# DRB CASE ACTION LOG (PREL & FINAL)

DRB Application No.: **07DRB-70169 (P&F)**  
Project Name : **RINCON DEL RIO ADDITION**  
Agent: **Jack's High Country**

Project # **1006715**  
Phone No.: **898-3707**

**PLAT OF  
LOTS 11-A AND 11-B  
RINCON DEL RIO**

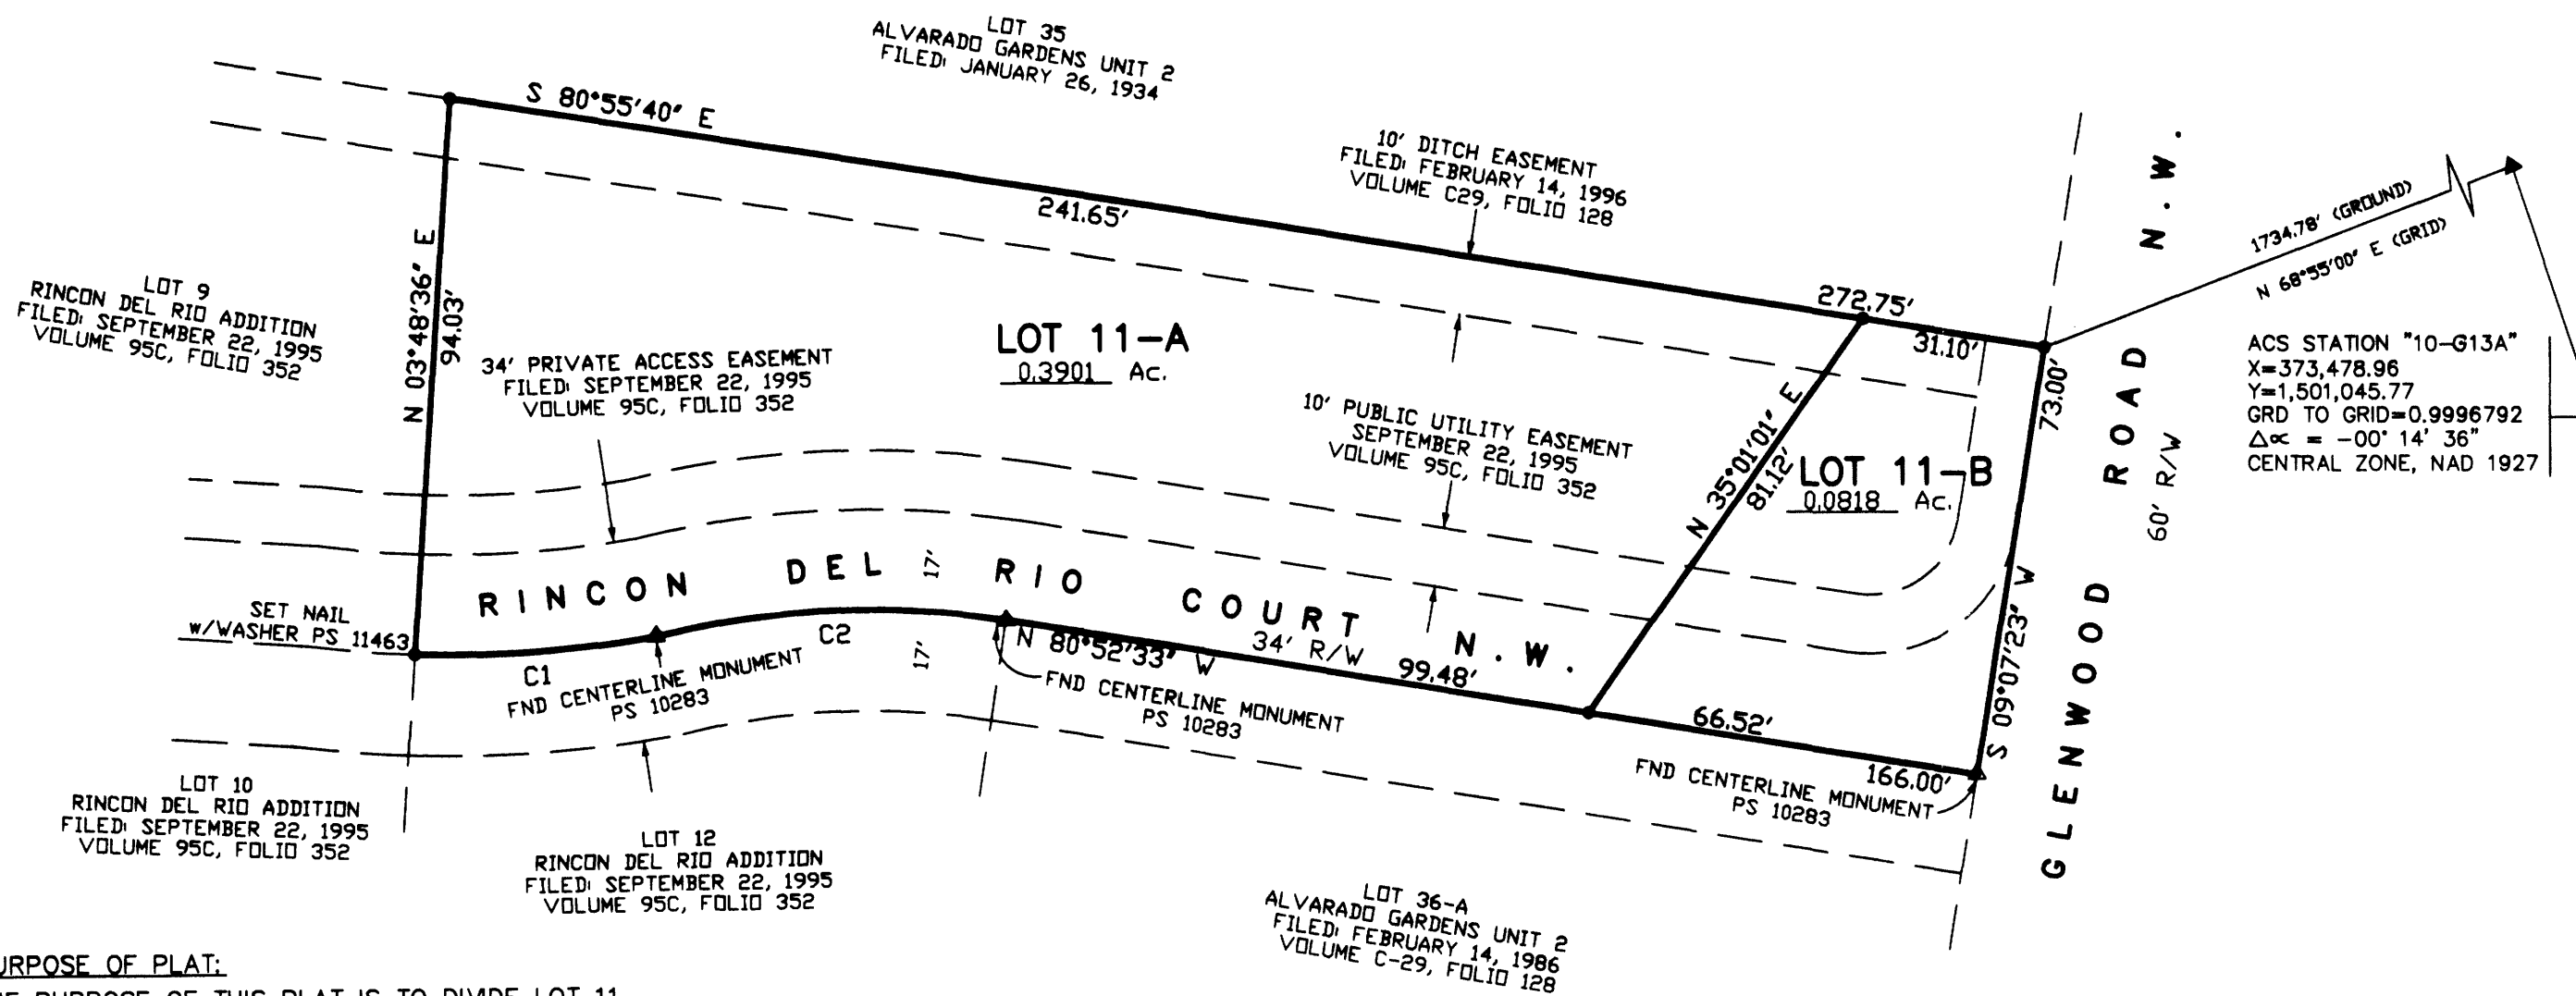
- TRANSPORTATION: \_\_\_\_\_
- \_\_\_\_\_
- \_\_\_\_\_
- \_\_\_\_\_
- \_\_\_\_\_
- ABCWUA: \_\_\_\_\_
- \_\_\_\_\_
- \_\_\_\_\_
- \_\_\_\_\_
- CITY ENGINEER / AMAFCA: \_\_\_\_\_
- \_\_\_\_\_
- \_\_\_\_\_
- \_\_\_\_\_
- PARKS / CIP: \_\_\_\_\_
- \_\_\_\_\_
- \_\_\_\_\_
- \_\_\_\_\_
- PLANNING (Last to sign): to clarify lot lines
- \_\_\_\_\_
- \_\_\_\_\_
- \_\_\_\_\_

~~The City of Albuquerque Subdivision Ordinance requires all newly created lots to be developable. This lot does not appear to meet that criteria.~~ *ok*
